Application for a non-material amendment following a grant of planning permission.

APPLICATION REF: 3/2016/0794 Decision Date 14 Oct 2016

Development: Demolition of rear outshoot and single garage and replacement with part two storey and single storey rear extension, detached triple garage and front garden wall.

We are requesting your consideration and permission to amend the landscaping plan. Your records will confirm that our original proposal was to replace an existing hedge at the front boundary following our moving back of the boundary by 1 metre (to allow for a better line of vision to traffic approaching from the ~~left~~ ^{right}). This was undertaken in accordance with the highways requirement. We now seek to amend this boundary in-fill with a stone wall instead of a planted hedge (please see image A attached) Wall/stone construction 80cm high

Proposed site plan

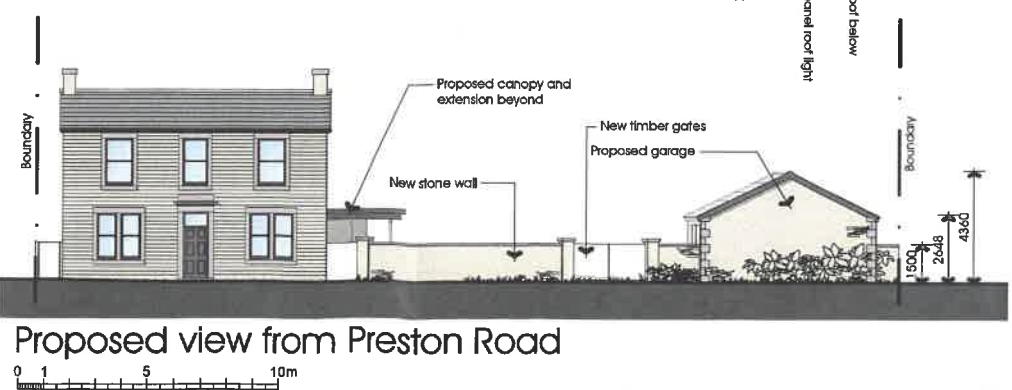
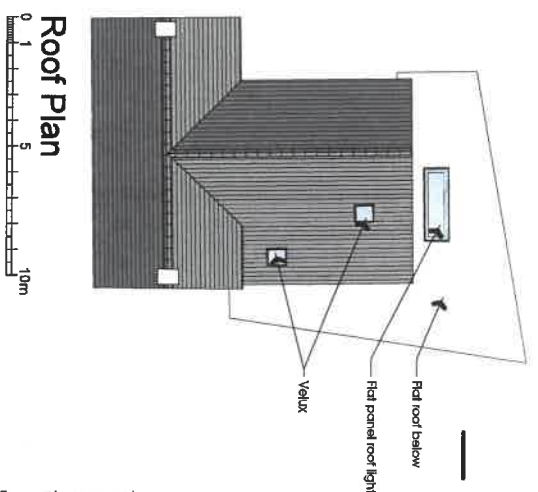
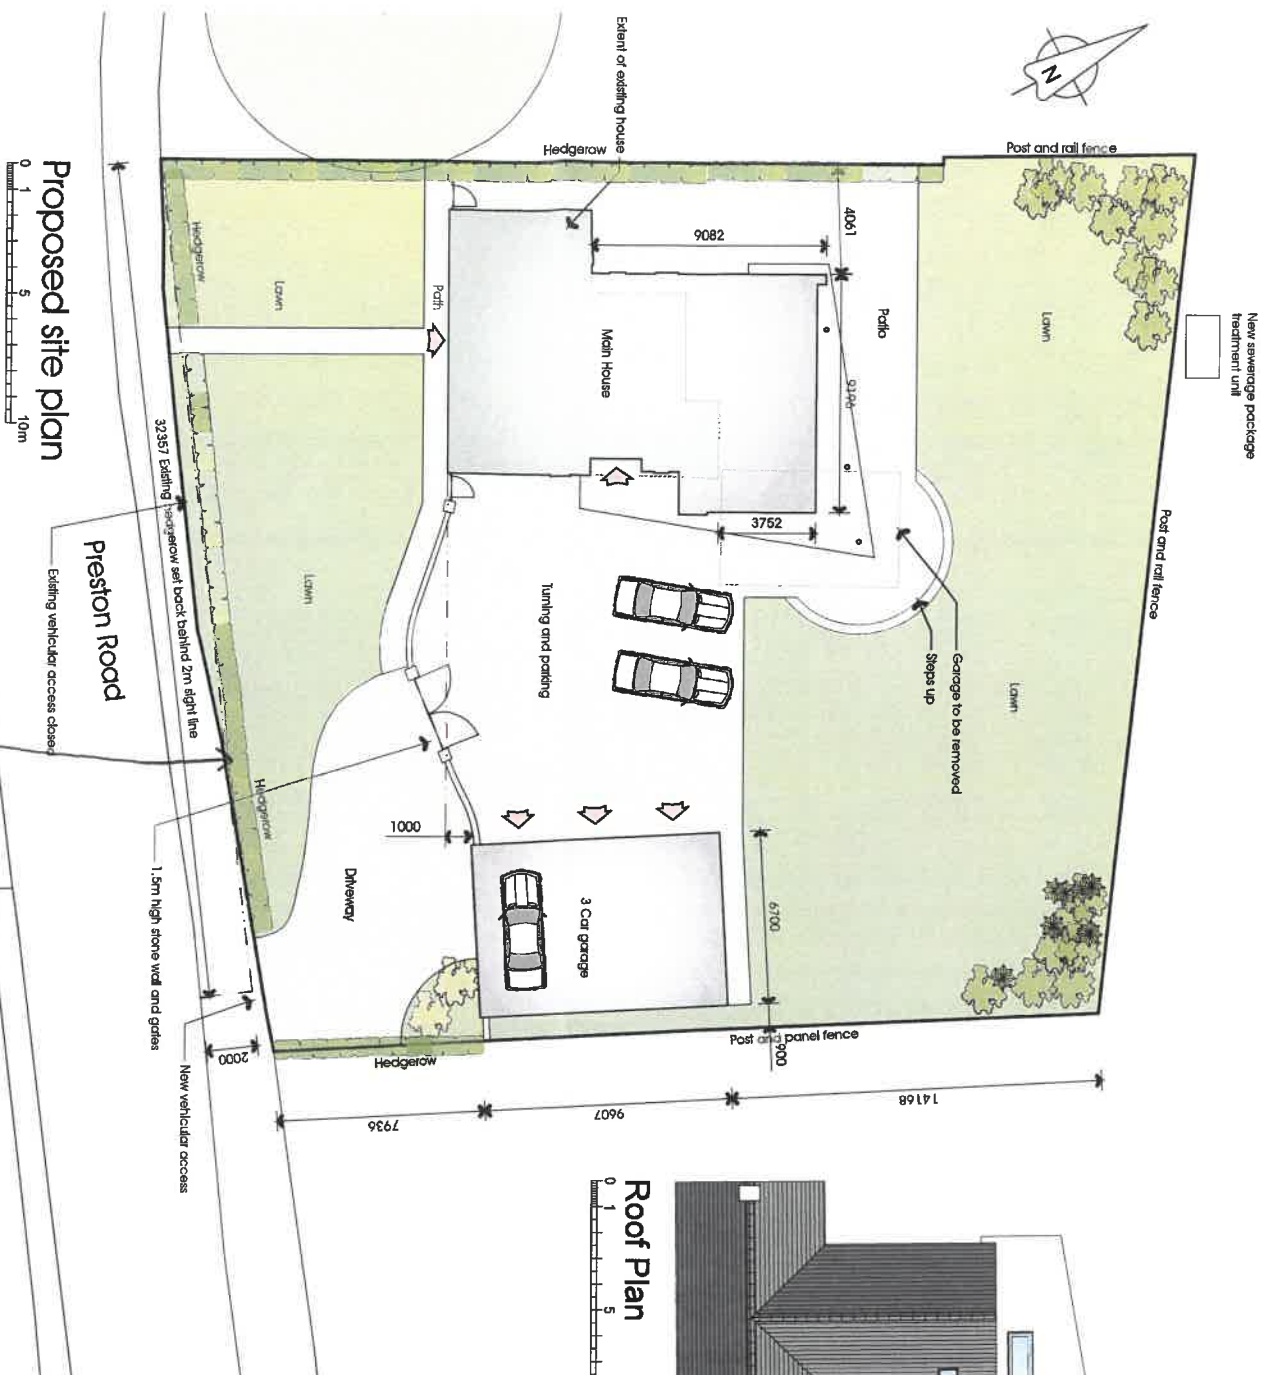
If we proceed and plant a hedge there will be a constant need to pin back/cut in order to maintain as clear a line of vision as possible. We are also concerned about the ability to keep our family dog safe and secure and would therefore prefer to construct a stone wall. We will still maintain a hedge but would prefer to plant this behind the wall (see image A)
